GEN 2.1	Comments on updated NPPF
LA reply	Solar farms continue to be classed as essential infrastructure in Annex 3. The December version of the NPPF also includes a new reference to solar but not in a context relevant to this application as it relates to buildings. References to 'renewable' are unchanged from the September 2023 version of the NPPF.
GEN 2.2	Comments on updated NPS
LA reply	EN1: Solar is quoted as one of the cheapest generators of electricity, the other is wind, and together they are likely to be the predominant sources in a net zero system in 2050. Storage is also important but many options are not yet available at scale. Hydro is part of the storage solution but has limited topographical capacity. EN3: The advice contained in the section on Solar does not appear to raise any issue that has not been considered as part of the application, including the matters the Secretary of State should consider in 3.10.143 to 3.10.153. EN5: Relevant owing to 1.6.3i but since the proposed cable is relatively short and underground the impact issues the NPS raise are ameliorated. Land rights and land interests are dealt with by the application.

GEN 2.4	The Applicant's response to

Project: Heckington Fen Energy Park
 Client: Ecotricity (Heck Fen Solar Park) Limited
 Title: Arboricultural Impact Assessment and Tree Protection Plan (Sheet 1 of 2)
 Drawing number: 22045_502
 Status: FOR INFORMATION
 Drawn By: GW
 Checked By: MR
 Date: 14-06-22
 Scale @ A3: 1:5000

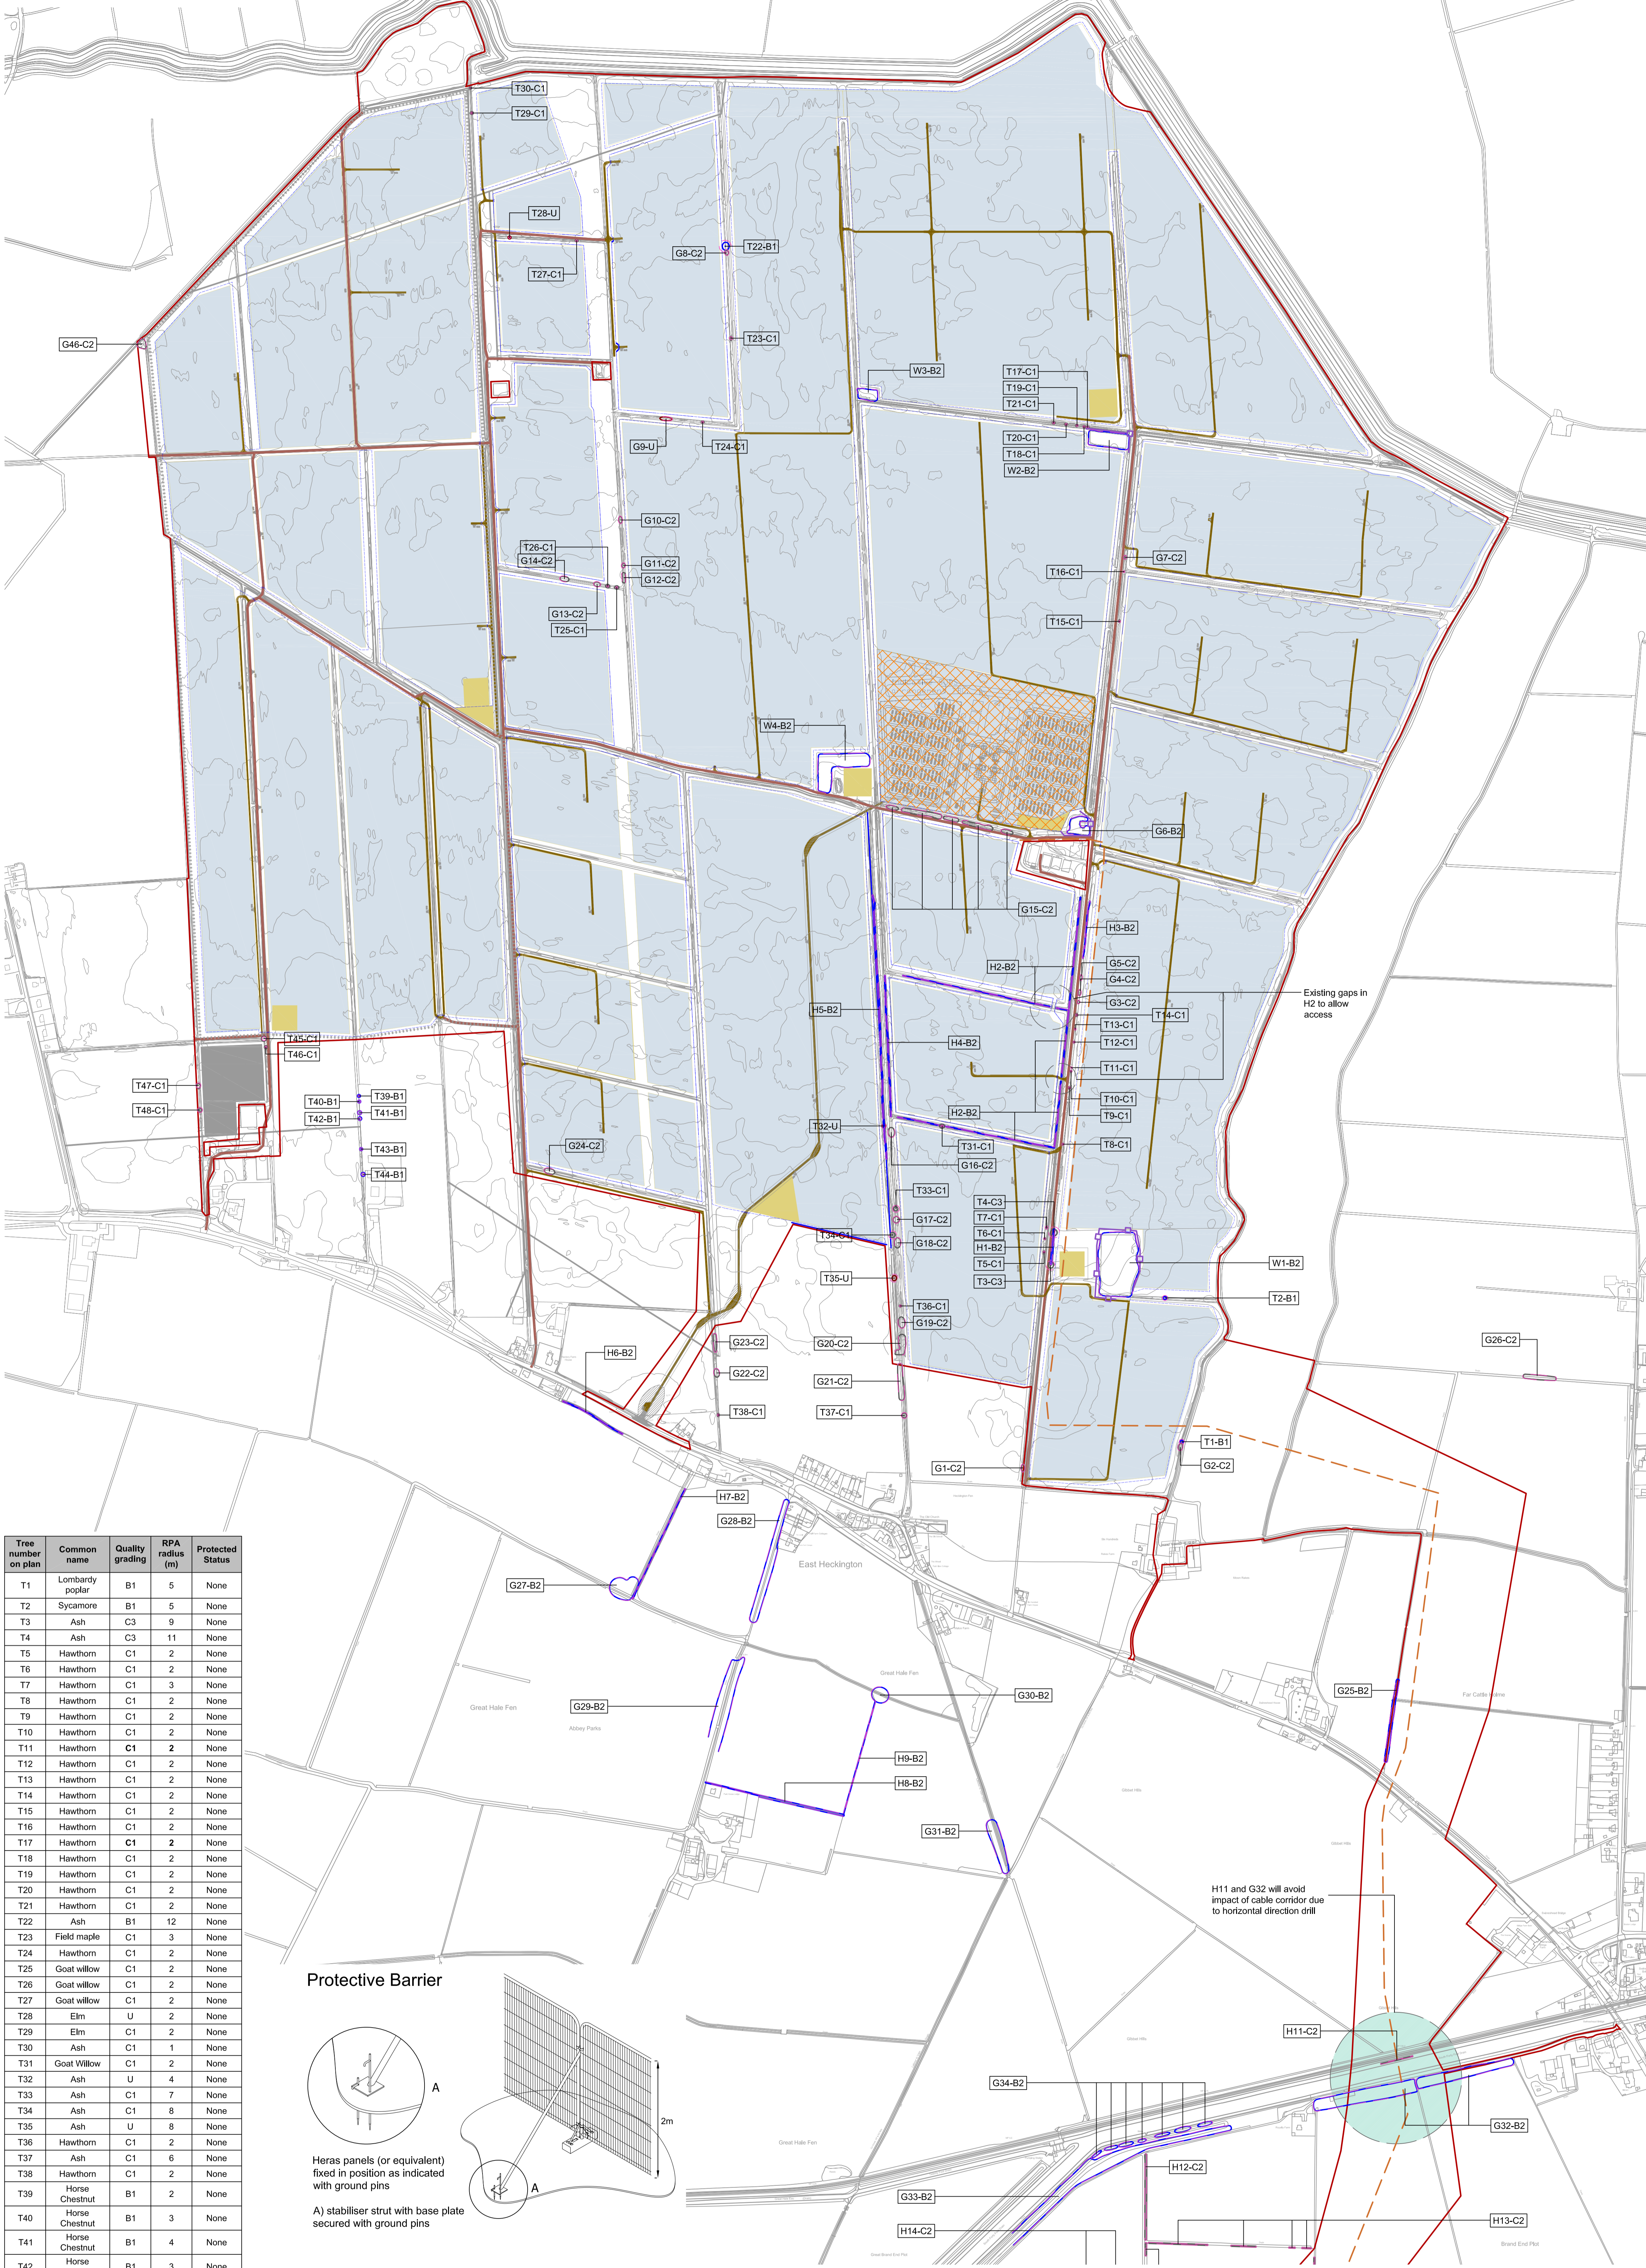
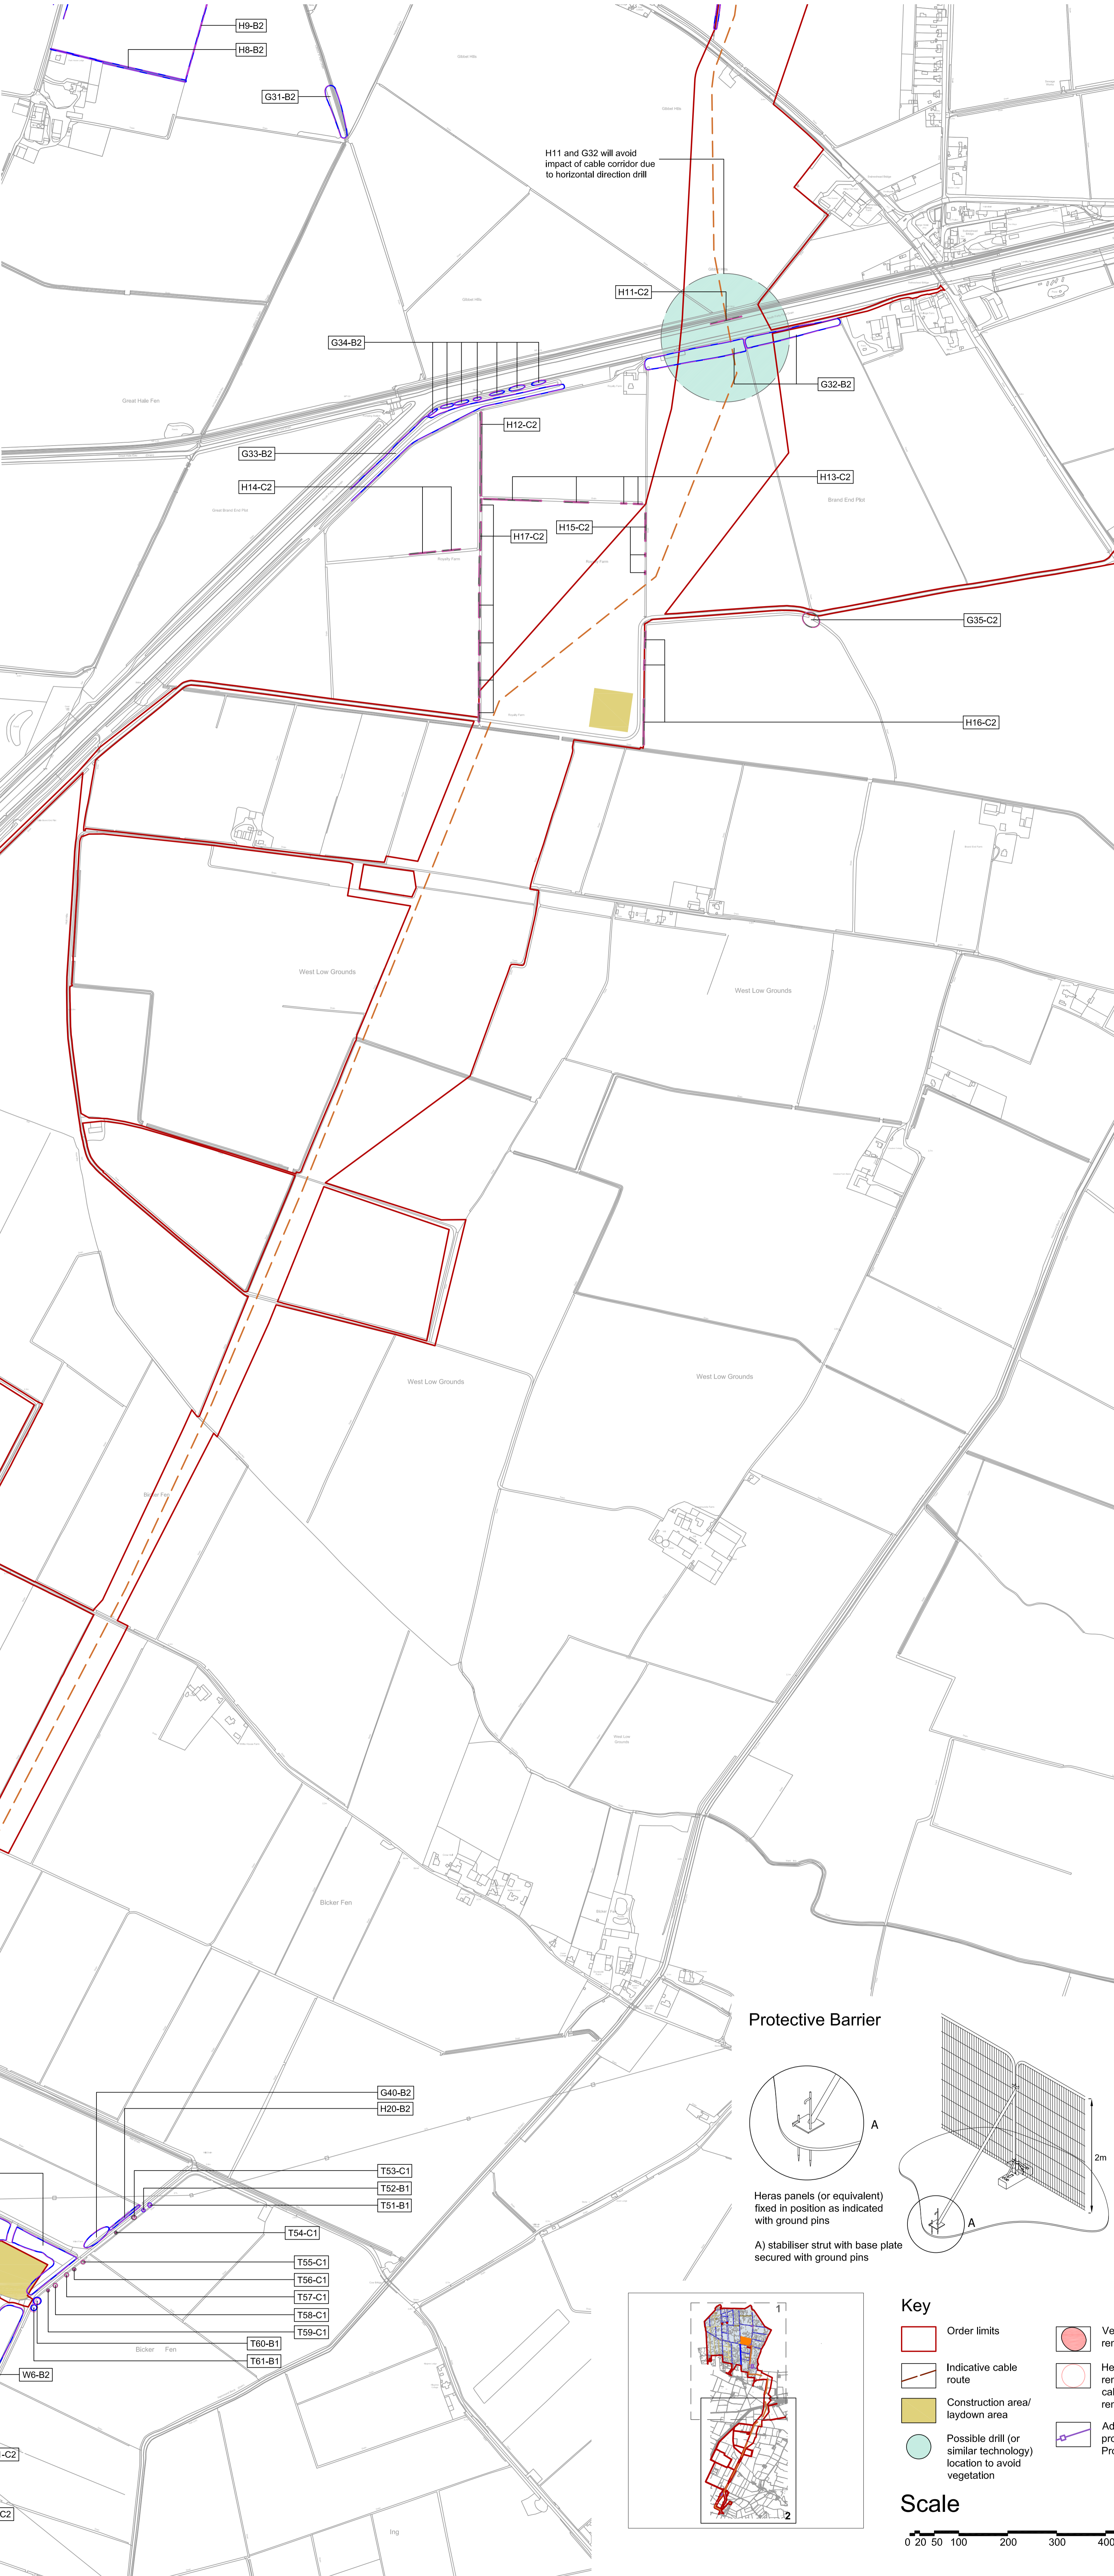
GEN 2.11	<p>The Applicant's response to ExQ1 BIO 1.5 [REP2-077] clarifies that a major beneficial effect relates to hedgerow resource only and that Table 6.10 ES Chapter 6 [PS-059] does not report tree resource during the construction phase as these effects were not deemed to be significant. Other non-significant residual effects are reported within Table 6.10.</p> <p>I. Could the Applicant provide further explanation why tree resource has been excluded from Table 6.10 or update it to include tree resource.</p> <p>In the Applicant's response to part iv) of ExQ1 BIO 1.5 it is stated that residual beneficial effects are reported solely on the quantum of the proposed vegetation rather than their maturity. Considering this relates to an assessment of the significance of a landscape feature it is unclear why maturity has not been considered.</p> <p>II. Could the Applicant provide an explanation of why they consider this is appropriate for the landscape assessment</p> <p>III. Could LCC, NKDC and BBC provide comment on the Applicant's response to ExQ1 BIO 1.5 [REP2-077].</p>

LA reply	<p>III. The applicant's response and the quoted document focus on the landscape impact of the Energy Park. They do comment on the loss of trees at the Bicker Fen substation and that the impact of their loss is balanced with the tree planting proposed at the Energy Park. The Borough Council understand this point of view as at a project level it makes sense. The Borough Council have commented on the loss of trees and the impact on the Borough. The applicants have suggested a resolution to their loss and the Borough Council agrees with it. There are very few, if any, hedges on the cable route and the applicants have offered to provide hedgerow planting as part of the suggested resolution to the tree loss in the Borough in order to provide connectivity of habitat. If the landowners agree to this offer there will also be a landscape benefit.</p>
